**From:**  
**Sent:** 13 October 2024 17:56  
**To:** DC Admin  
**Cc:** 'Helen Whitworth'  
**Subject:** 168 Scholes Lane, Scholes, Cleckheaton BD19 6LX - Application number 2024/92316

I am writing regarding the above application number as the owner of 164 Scholes Lane, Scholes, Cleckheaton BD19 6LX as, if passed, the proposed residential development could impact my property so I would like to raise some queries/concerns that I have:

SITE PLAN 1:500

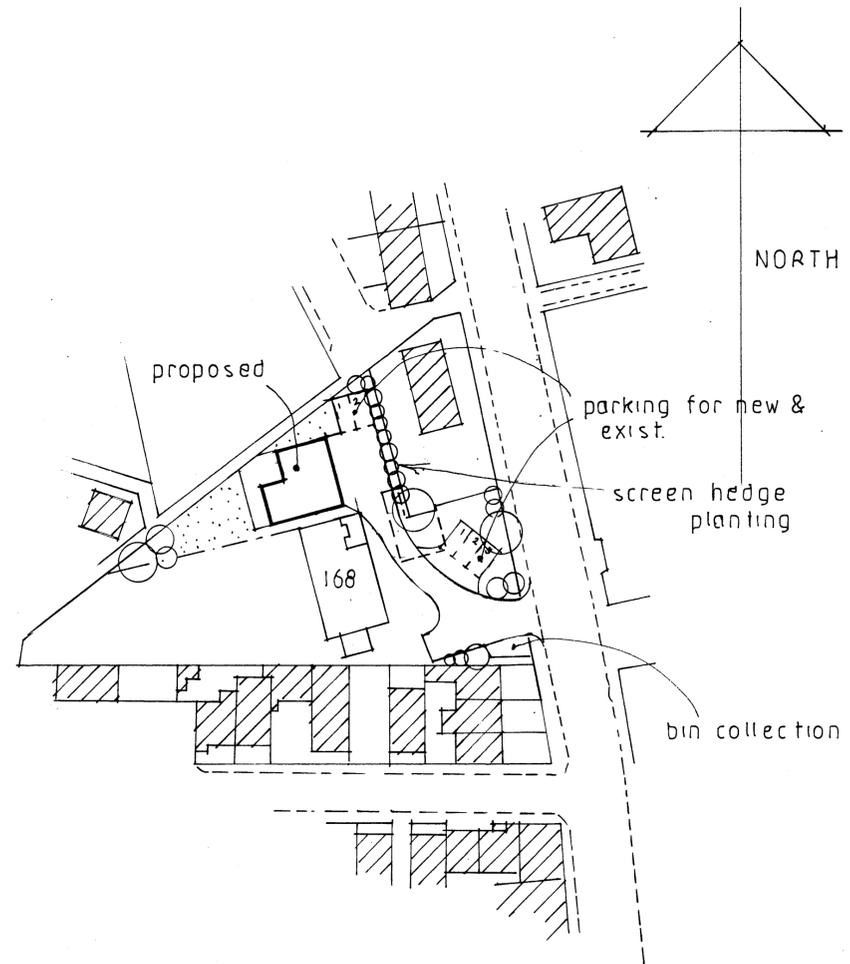
1.) I would like to understand where it is intended that the proposed dwelling will be connected to the sewer system. The reason I ask is that I understand my late father agreed that the owner of 168 Scholes Lane could run a single sewage pipe from their property across the boundary between 168 and 164 to a small junction which then connects to the drainage system of 164, before connecting to the mains sewer. This was an informal agreement.

I am, therefore, concerned that if permission is granted and intention would be to connect the proposed dwelling to the existing single sewage pipe. This will not support another dwelling and could lead to blockages and potentially raw sewage leaking onto my land.

2.) The plans propose the demolition of the existing garage which is a very old dry stone wall structure and is a habitat for nature, especially birds and bats. It also forms part of the boundary between 168 and 164 and provides privacy for 164 from 168 which is in an elevated position. I would like to understand what will be put in its place, considering this is a conservation area, to protect the privacy of 164 and what conditions will be put in place to protect the nature and wildlife it supports.

3.) The plans and drawings do not accurately reflect the building footprint of 164 as this has recently been developed and a double height extension added to the back (planning reference 2022/62/91435/E) which is closer to the boundary with 168. I would expect this to be considered and also the distance of the property from the Kirklees Way which runs the length of the boundary to the south.

4.) Given that 168 is in an elevated position relative to 164, I would want assurance that any water run off created by the new driveway would not cause an issue to 164. Currently most of the land earmarked for the proposed dwelling is used as a vegetable patch and, therefore, any rainwater soaks away which it wouldn't be able to do if hitting a surface such as tarmac.

5.) I have a well-established beech hedge running along the boundary between 164 and 168 which was planted around 50 years ago. The proposed parking area for two cars is very close to the boundary, I would want consideration to be given to the hedges root spread so that any building work would not damage or kill the hedge. This hedge creates privacy to the rear of 164.
